**Ref No:** F2020/00663

Application No: SSD-10831778

**Re: Randwick City Council submission on the State Significant Development SSD-10831778 – Sydney Children’s Hospital Stage 1 and Children’s Comprehensive Campus Centre (SSD-10831778)**

2 PROPOSED HOURLY SHADOWS - JUNE 21 - 3 PM
1 : 1500

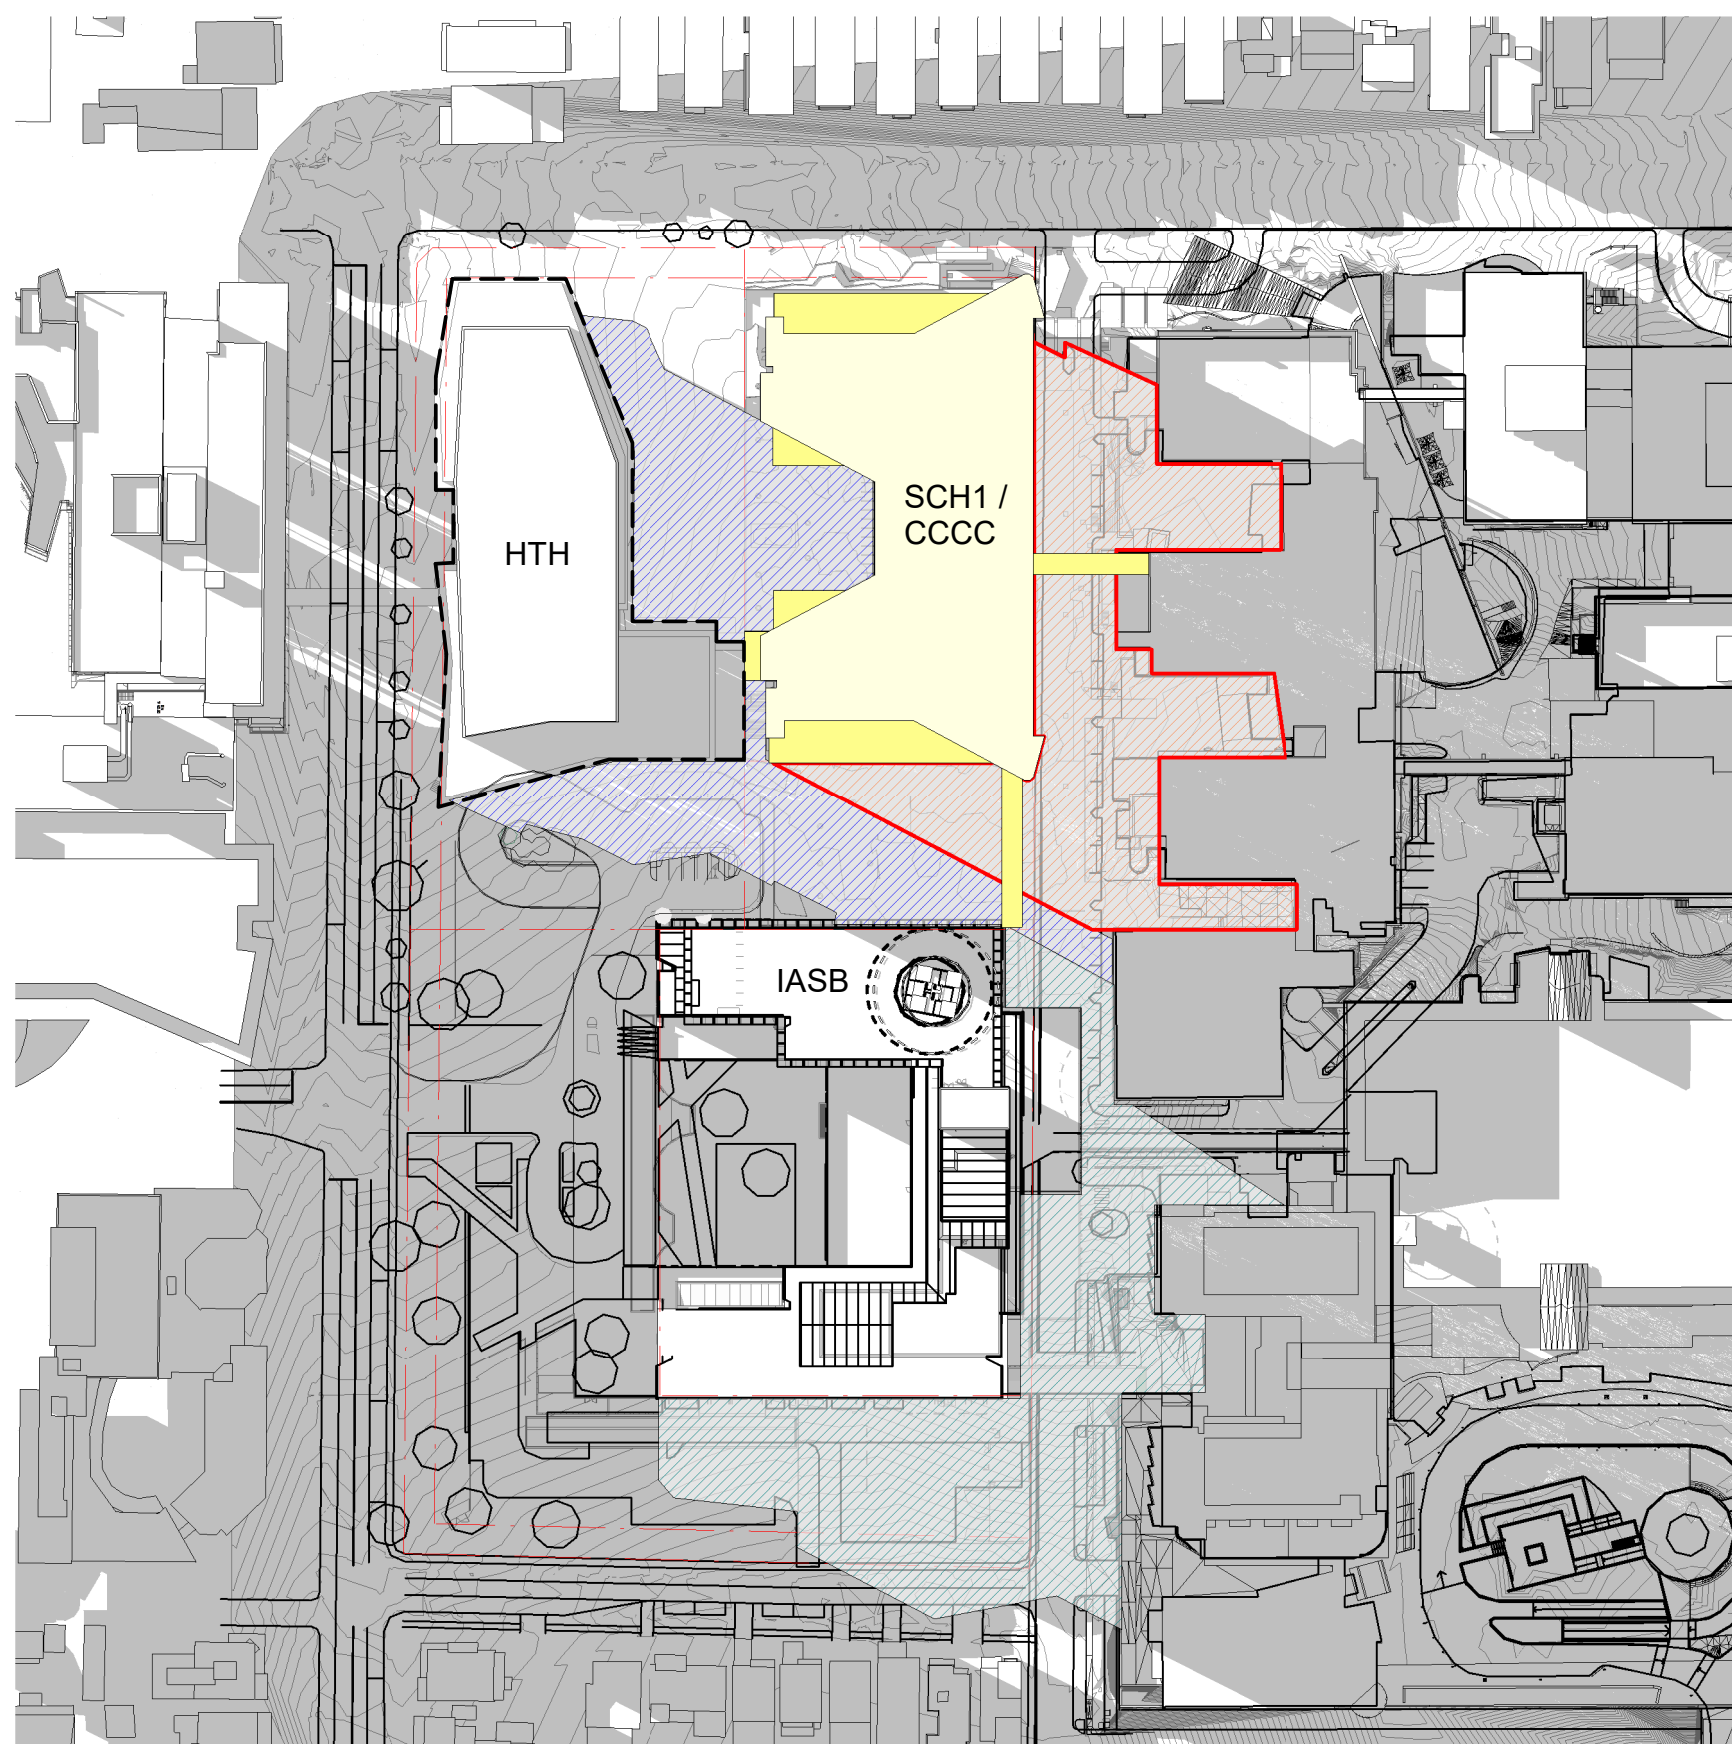
33. Shadow studies should be provided at hourly intervals for the winter solstice to assess solar access to the key public domain areas such as the plaza and children's play area.
